25 September 2012

**THE PROPOSED TOURIST AND RESIDENTIAL DEVELOPMENT  
AT CYPRESS CRESENT, CABARITA BEACH  
(MP09\_0016)**

Drawing Title: **ROOF PLAN**

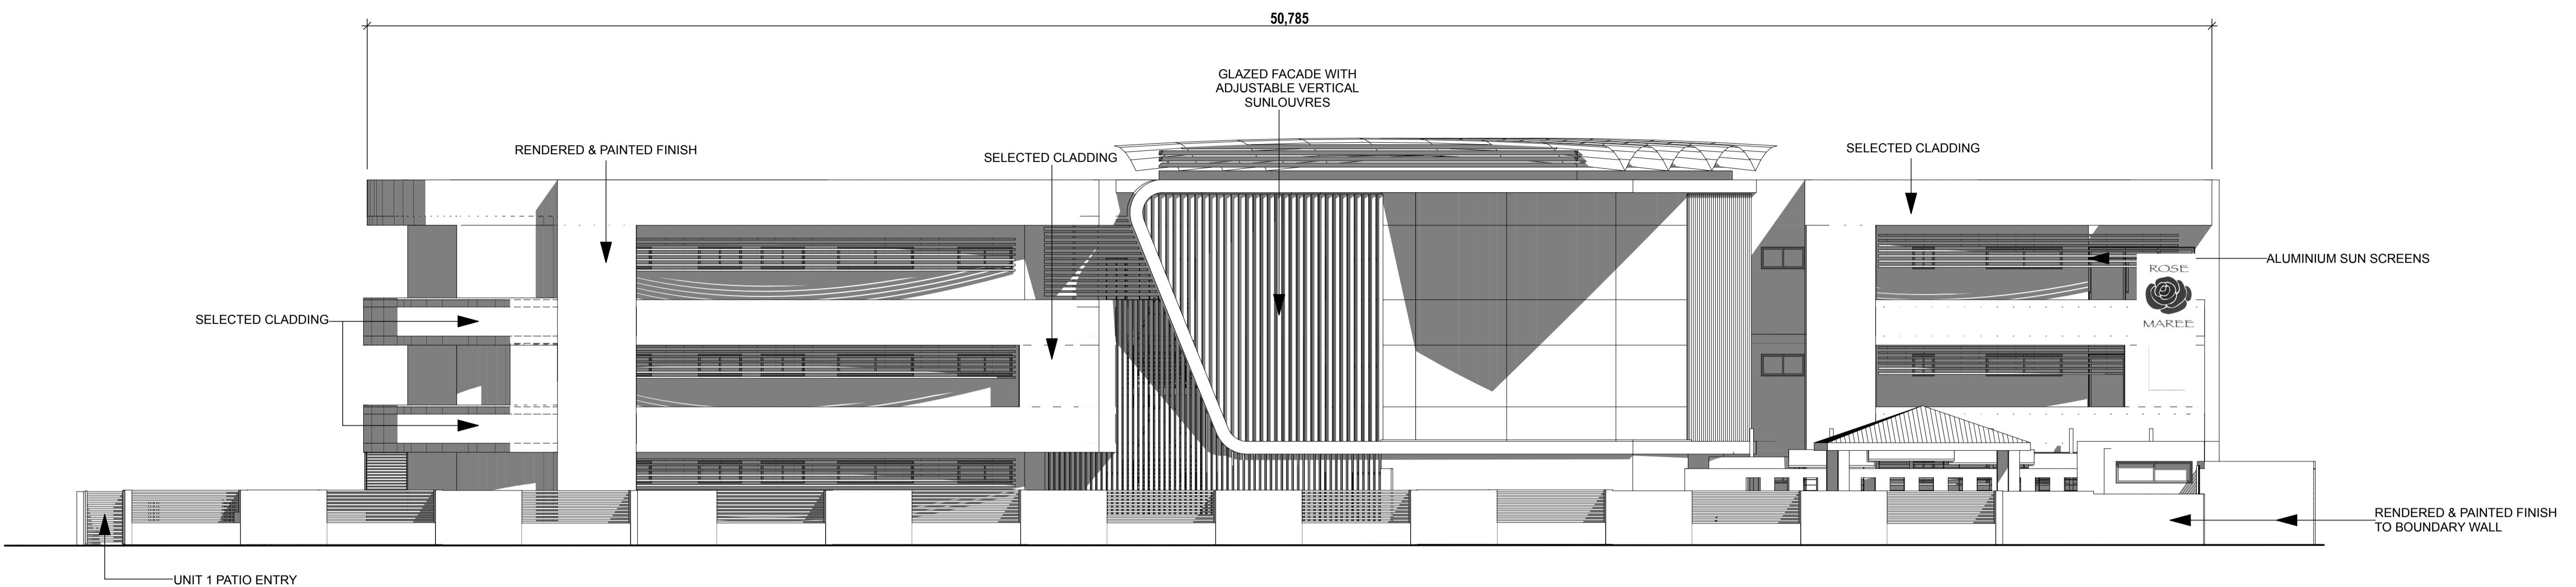
- breaking up the continuous roof line (consideration be given to change the roofline of the unit at both ends and/or breaking it into 3 wings, east, west and centre, and/or deleting one of the central unit at level 2);

- deleting the roof terrace, the spiral stairs case to roof terrace and the over-hanging roof element;
- amending the circulation core/walkway fronting the Tweed Coast Way to provide additional modulation to the building façade (See Figure 3 below); and
- the cabana be set back at least one metre from the eastern boundary so as to provide a continuous landscaping area along the eastern boundary.

- the deletion of one of the central unit at level 2 to allow set back and break up of the roofline;

WEST ELEVATION
1:100 @A1

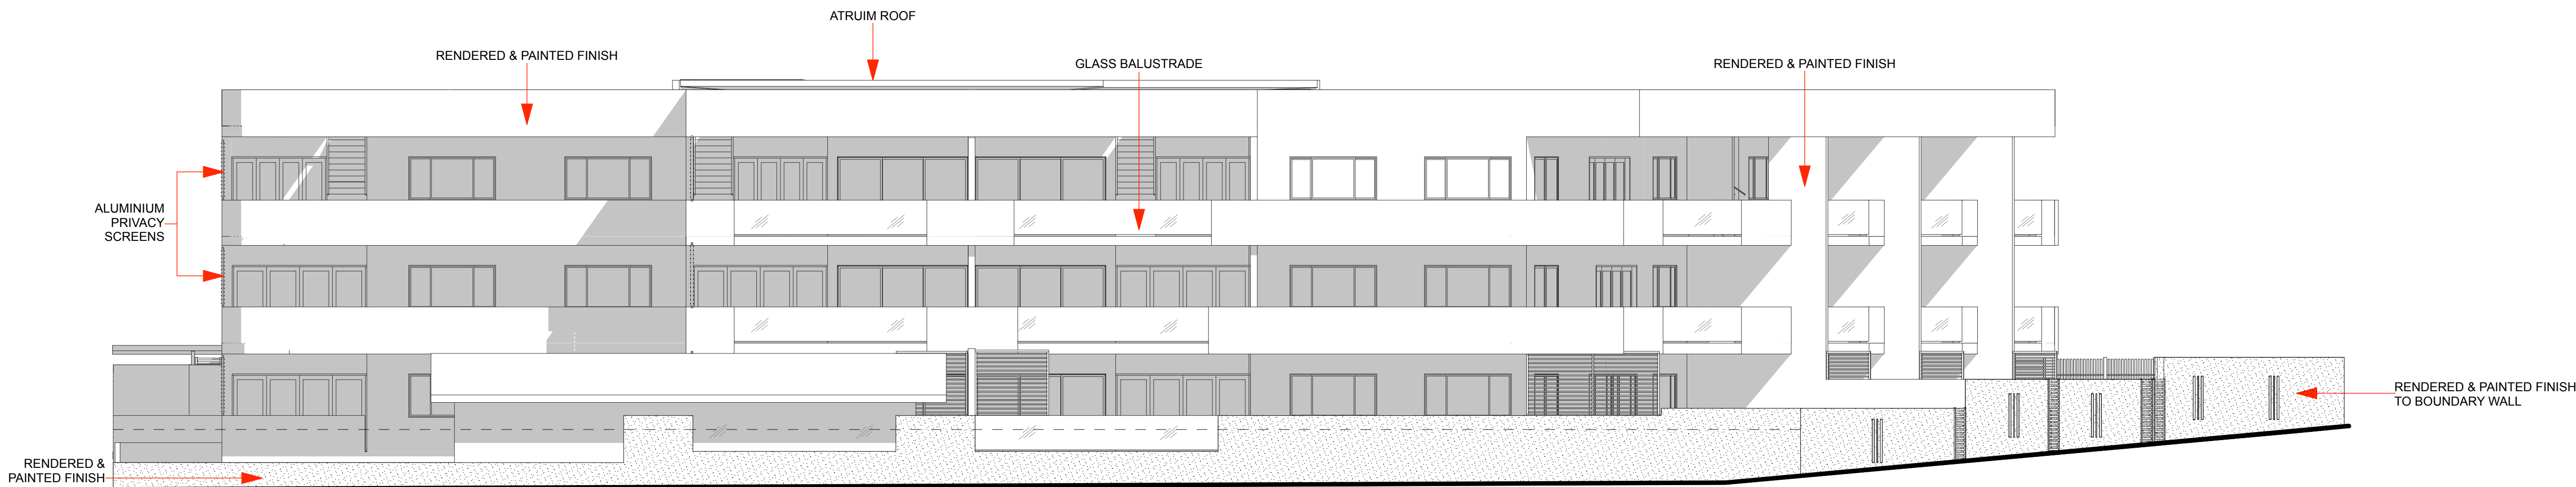
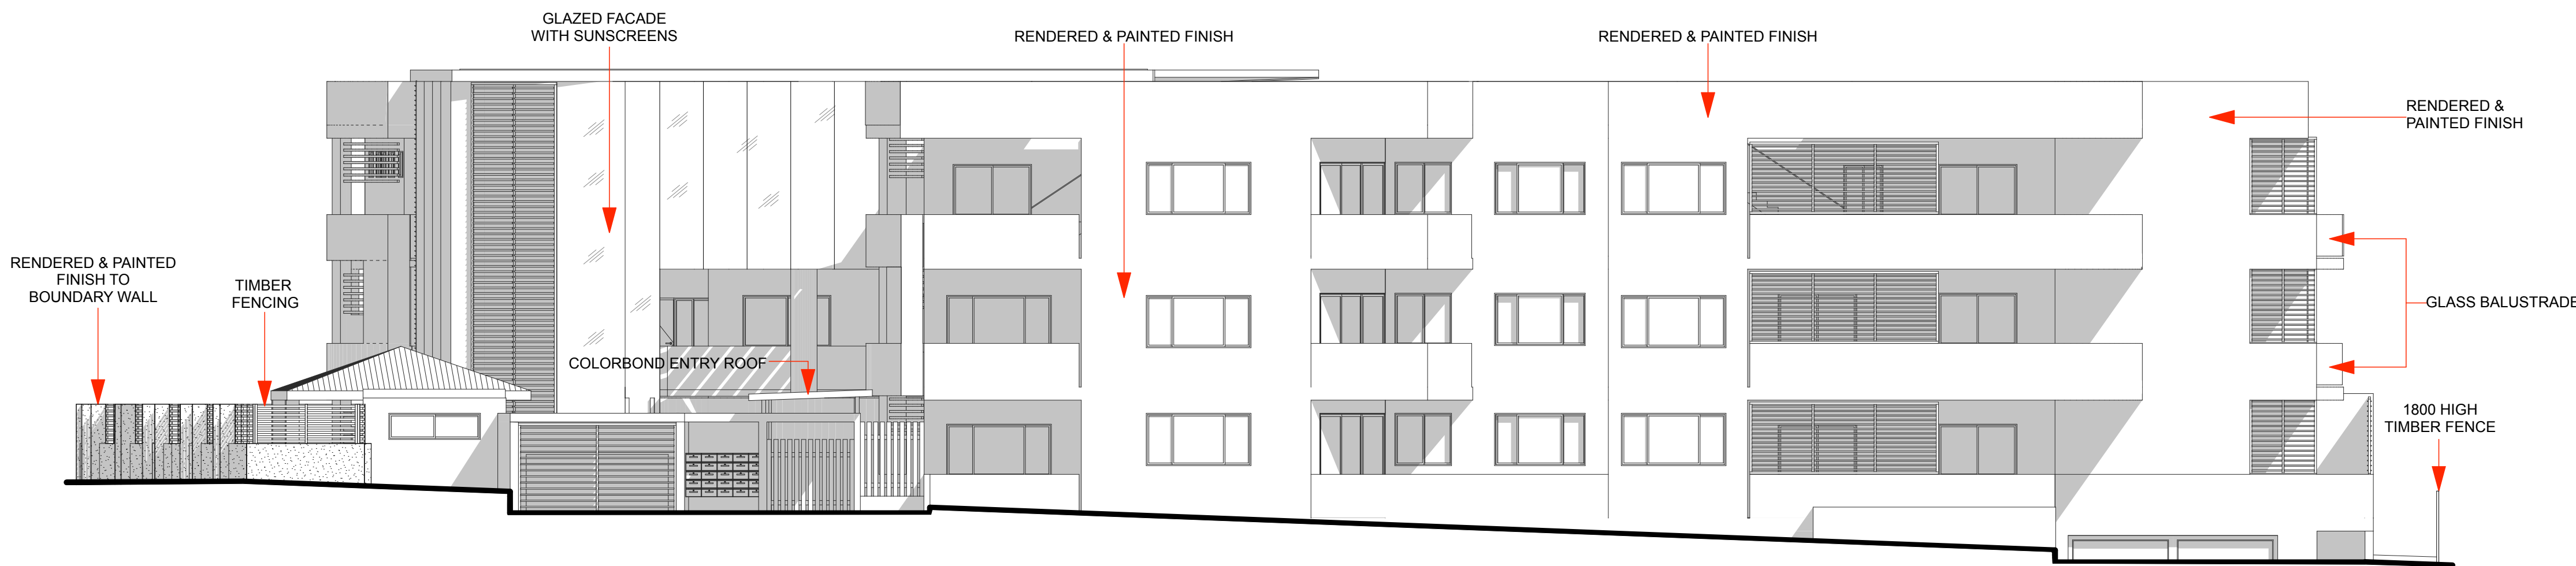
Although the amendment plans have improved the appearance of the built form, the Commission considers further improvement can be achieved by:
